From: Peter Bloem
Sent: Friday, 19 May 2017 6:25 PM
To: Chloe Dunlop
Cc: Chris Kelly - Wollongong
Subject: FW: Response to Comments - Joe White Maltings, Minto

I refer to the Joe White Maltings (Cargill) MP 08_0157 Modification 4. I am taking over the management of this project from the Department's Senior Planning Officer Kerry Hamman.

Subject: RE: Response to Submissions - Joe White Malting (Cargill) MP 08_0157 Modification 4 (email 2)

Figure 3 Inbound Operational Truck Route from the South

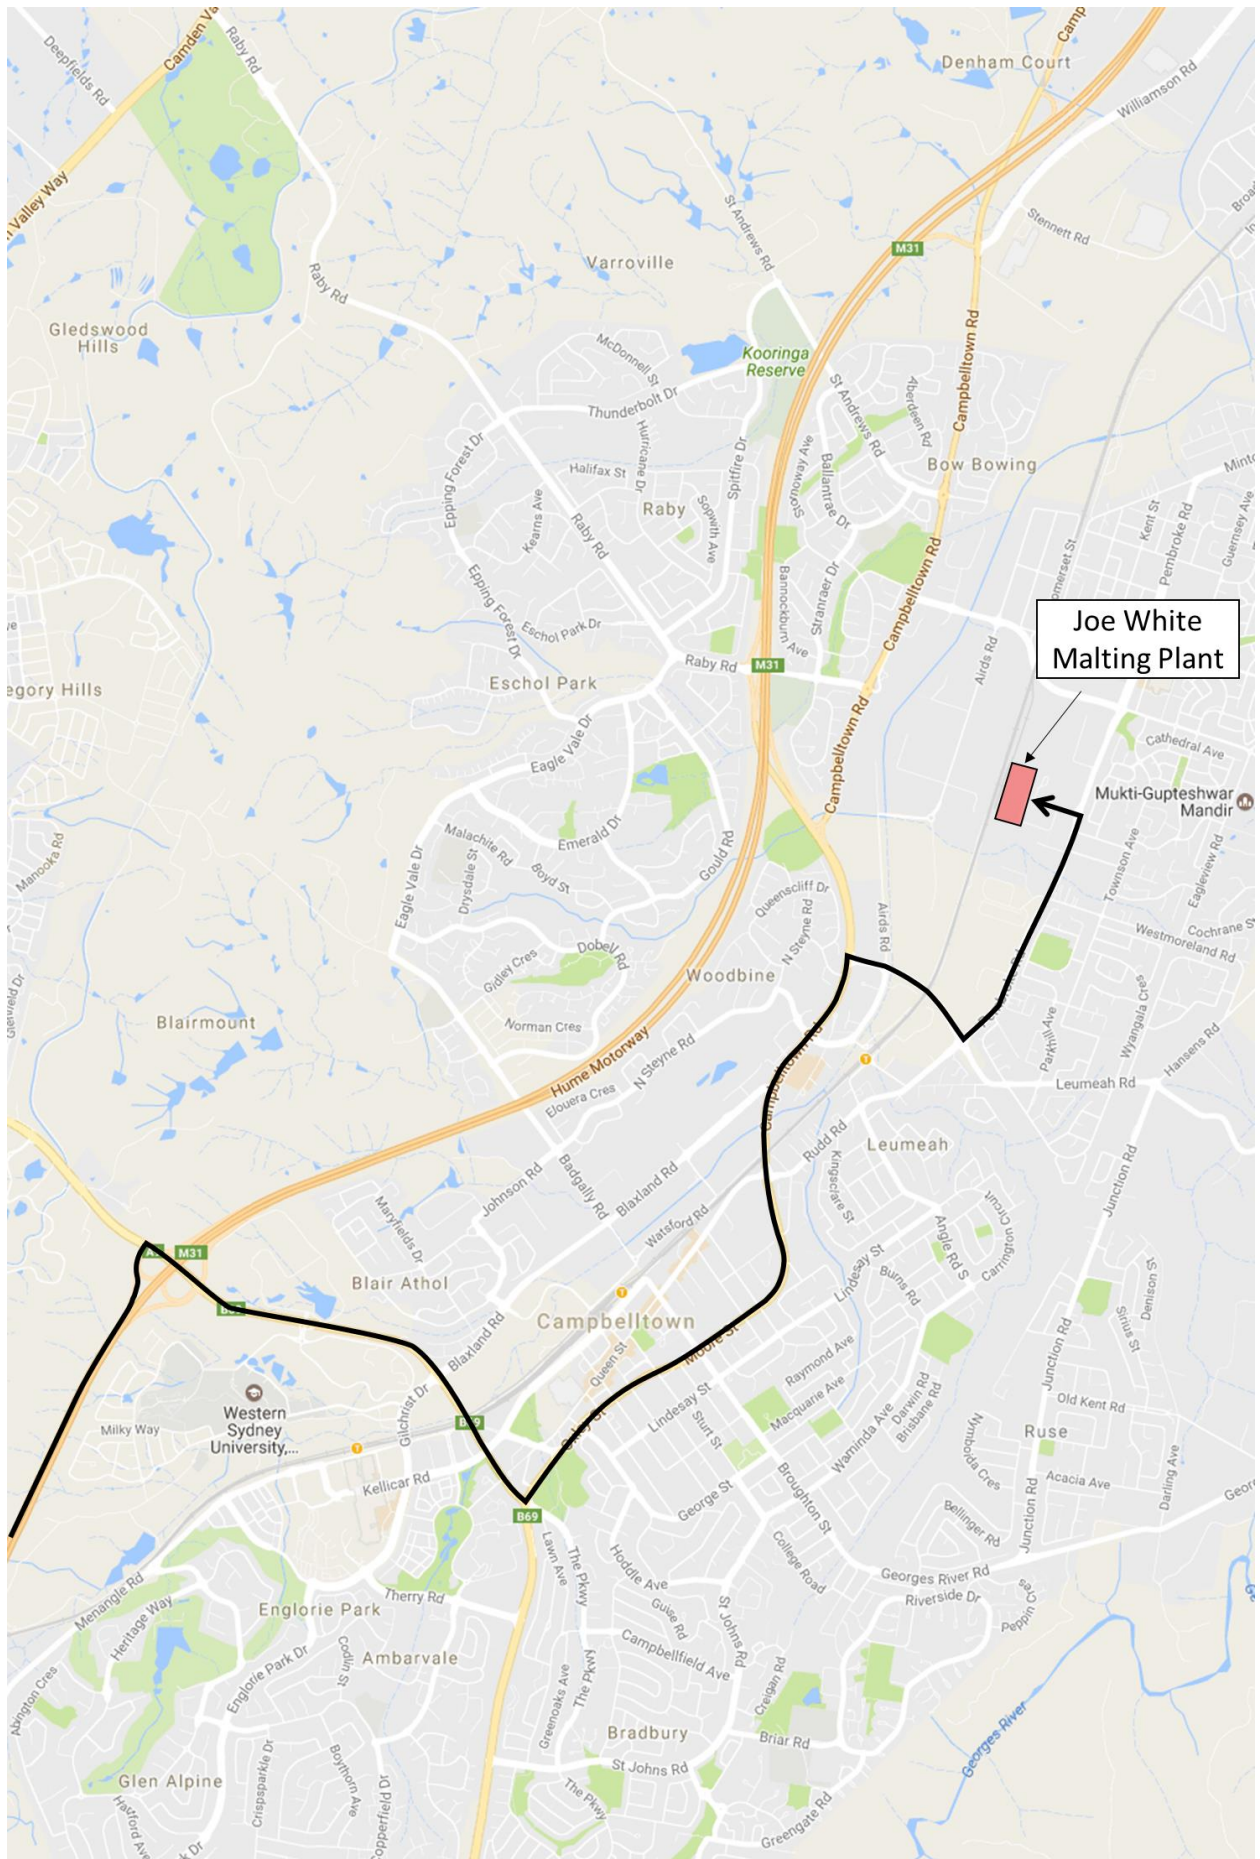
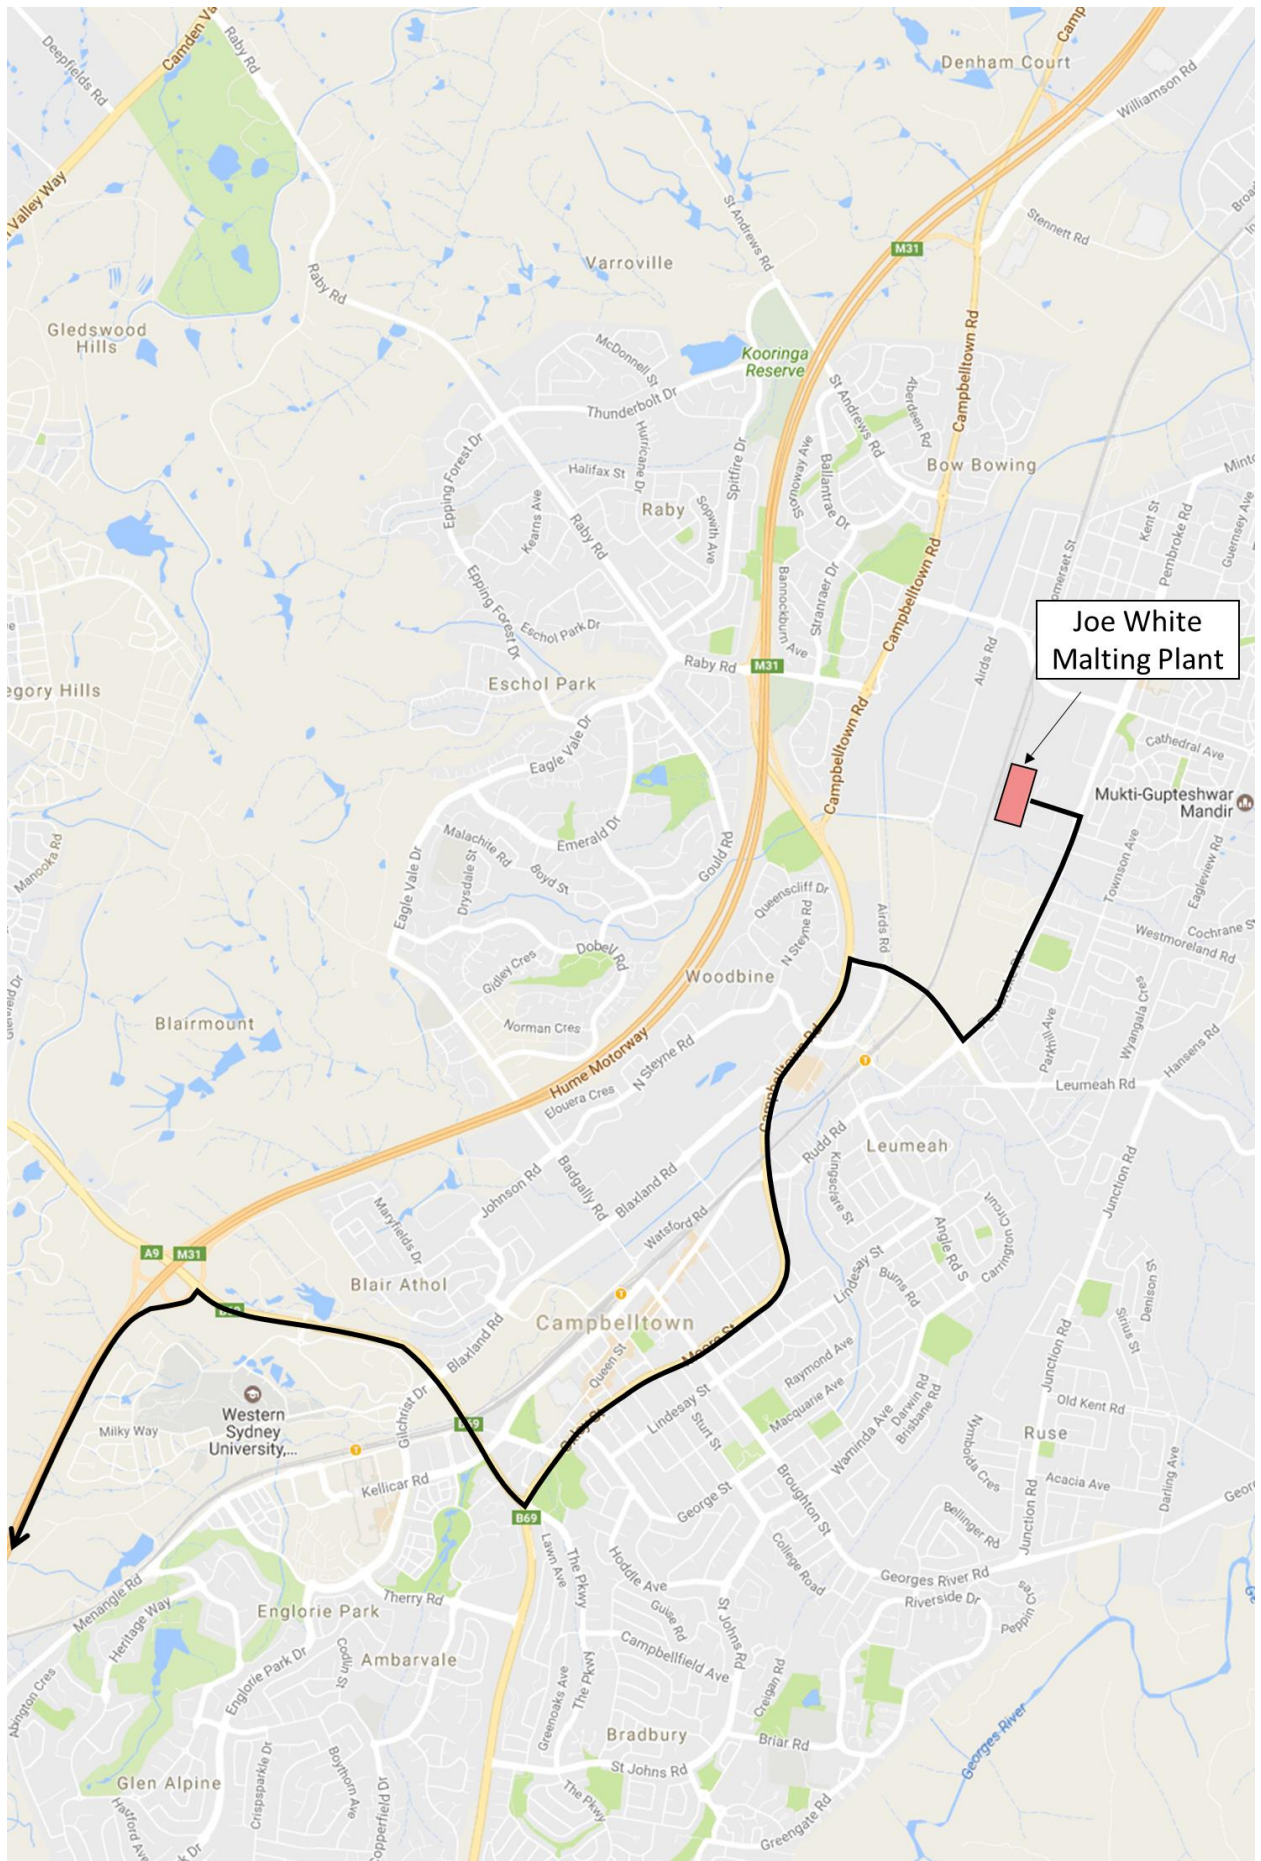
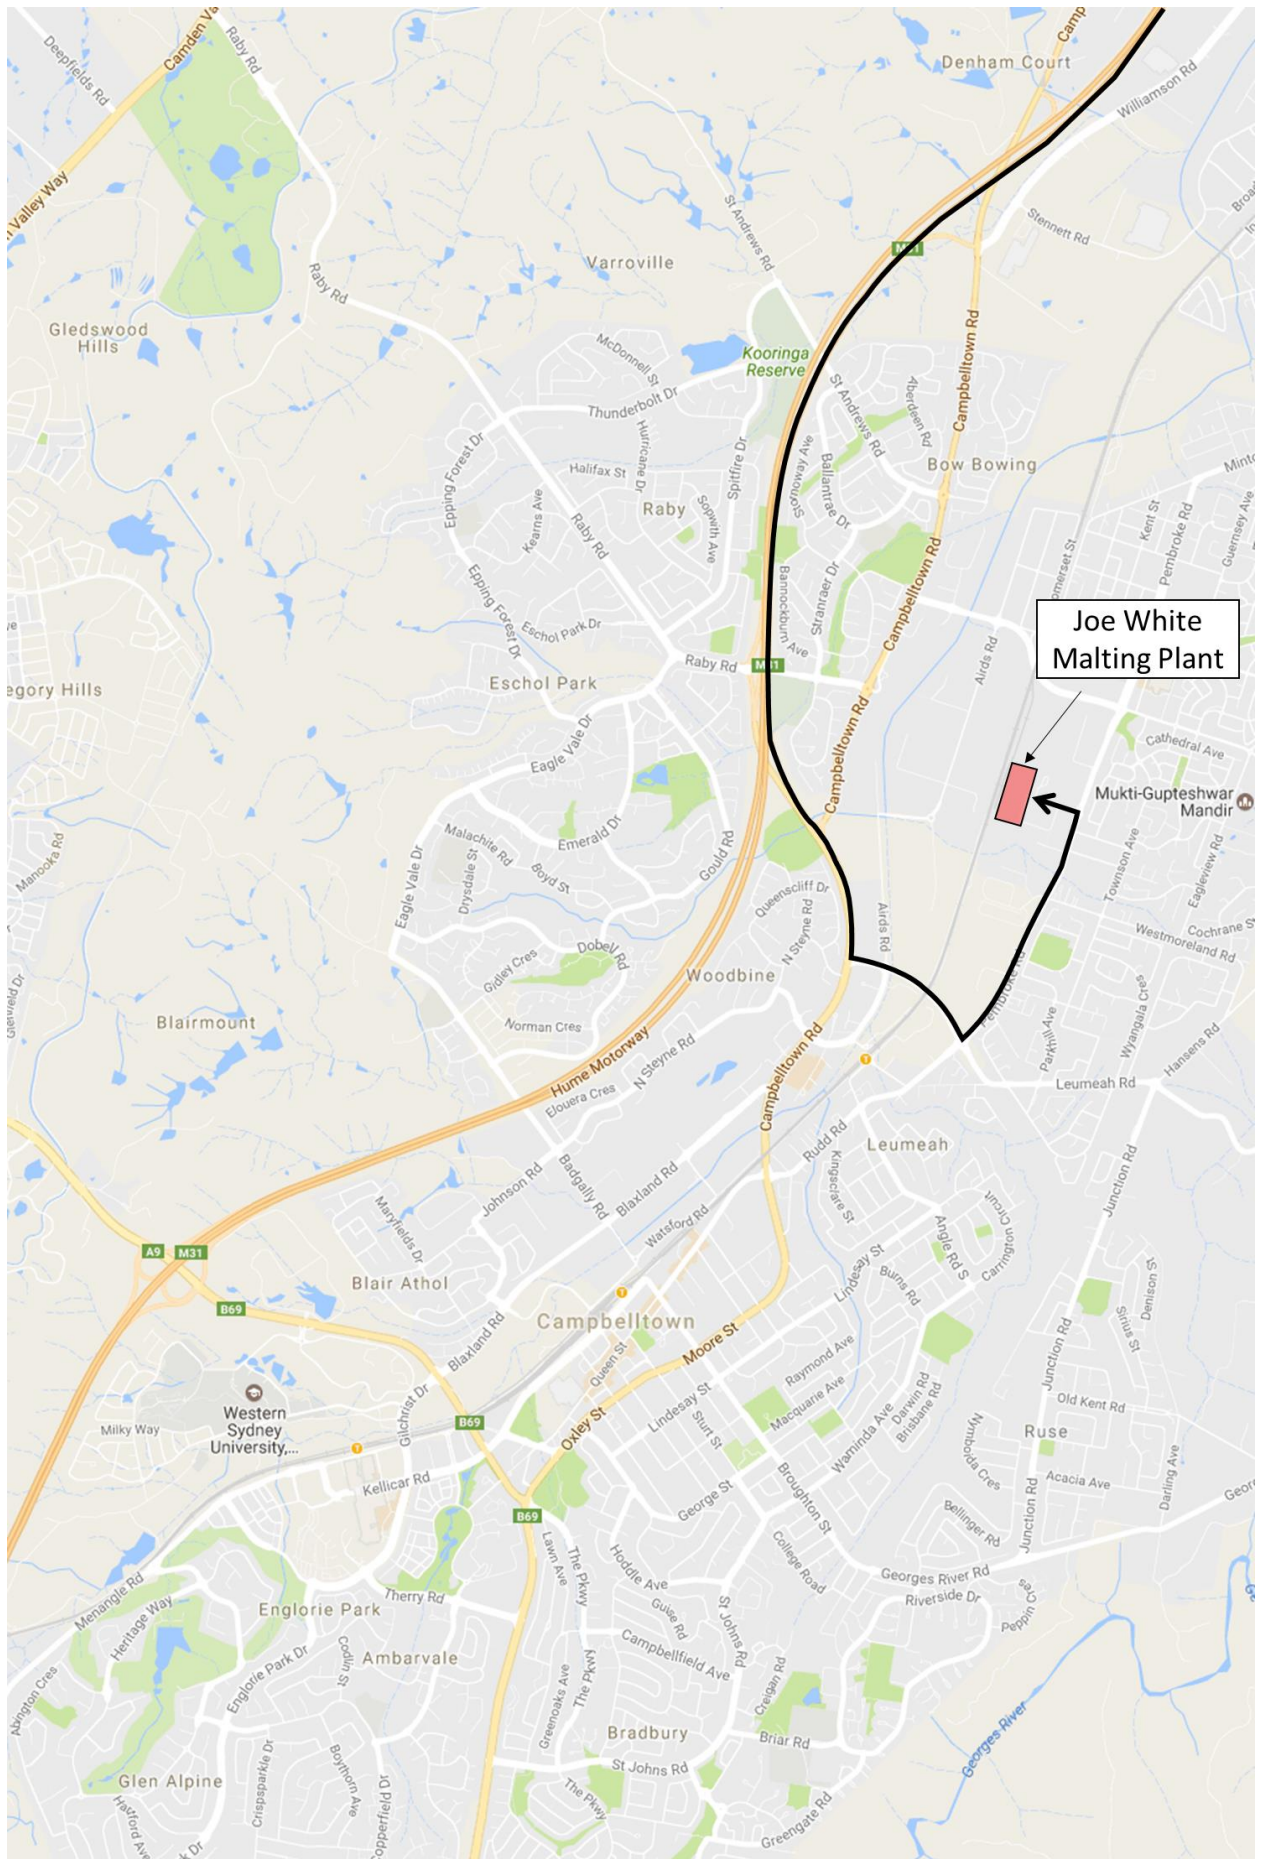
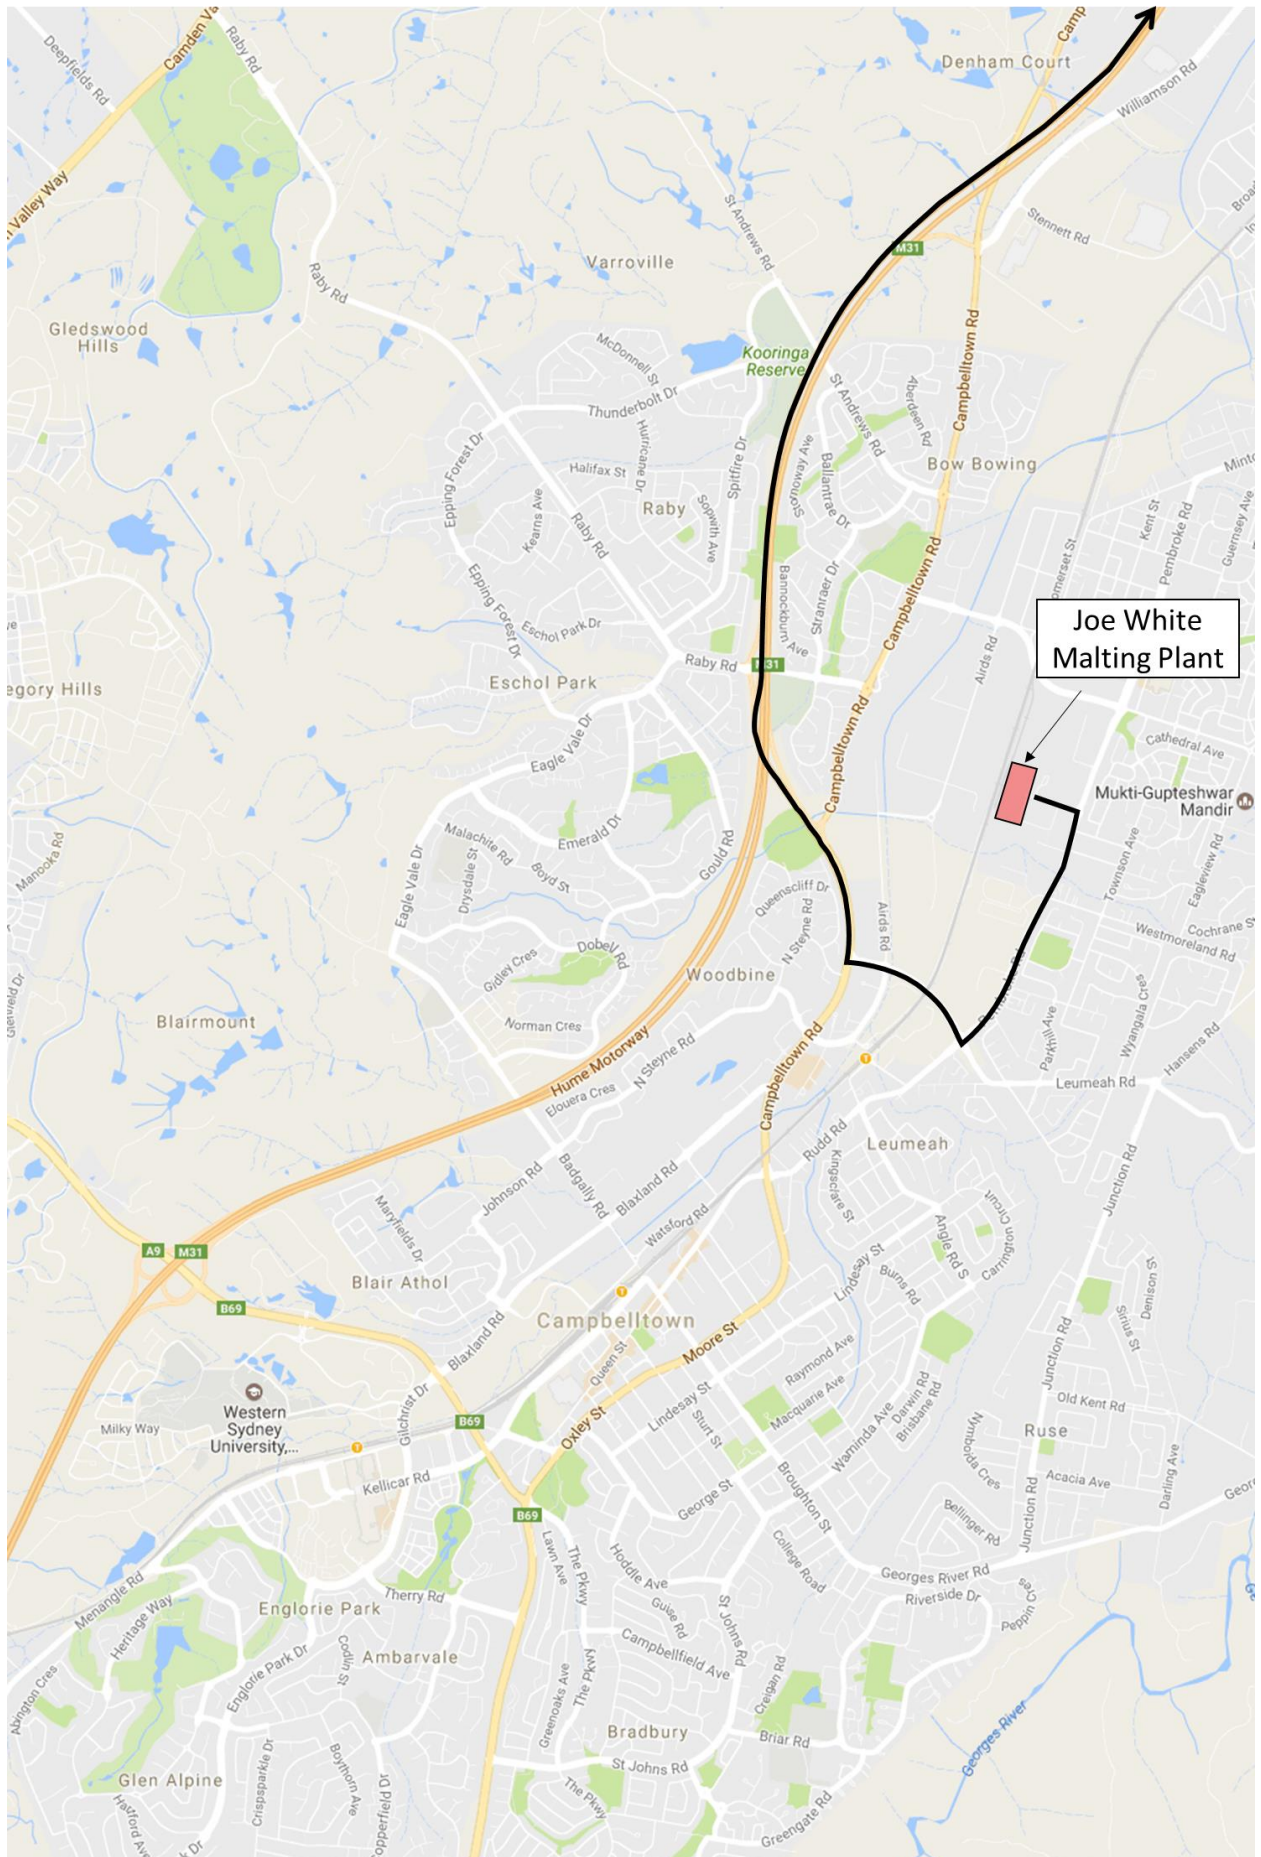
- The truck routes on page 6 and in Appendix C of the proponent's 'Operational Traffic Management Plan' do not appear to consider the 40 tonne load limit that is applied to the bridge on Ben Lomond Road (between Airds Road and Carey Grove). Further, the right turn proposed from Campbelltown Road to the Hume Highway north is not possible. There are no right turn facilities in that location. A revised route for those movements impacted by the load limit and turn treatments shall be provided.
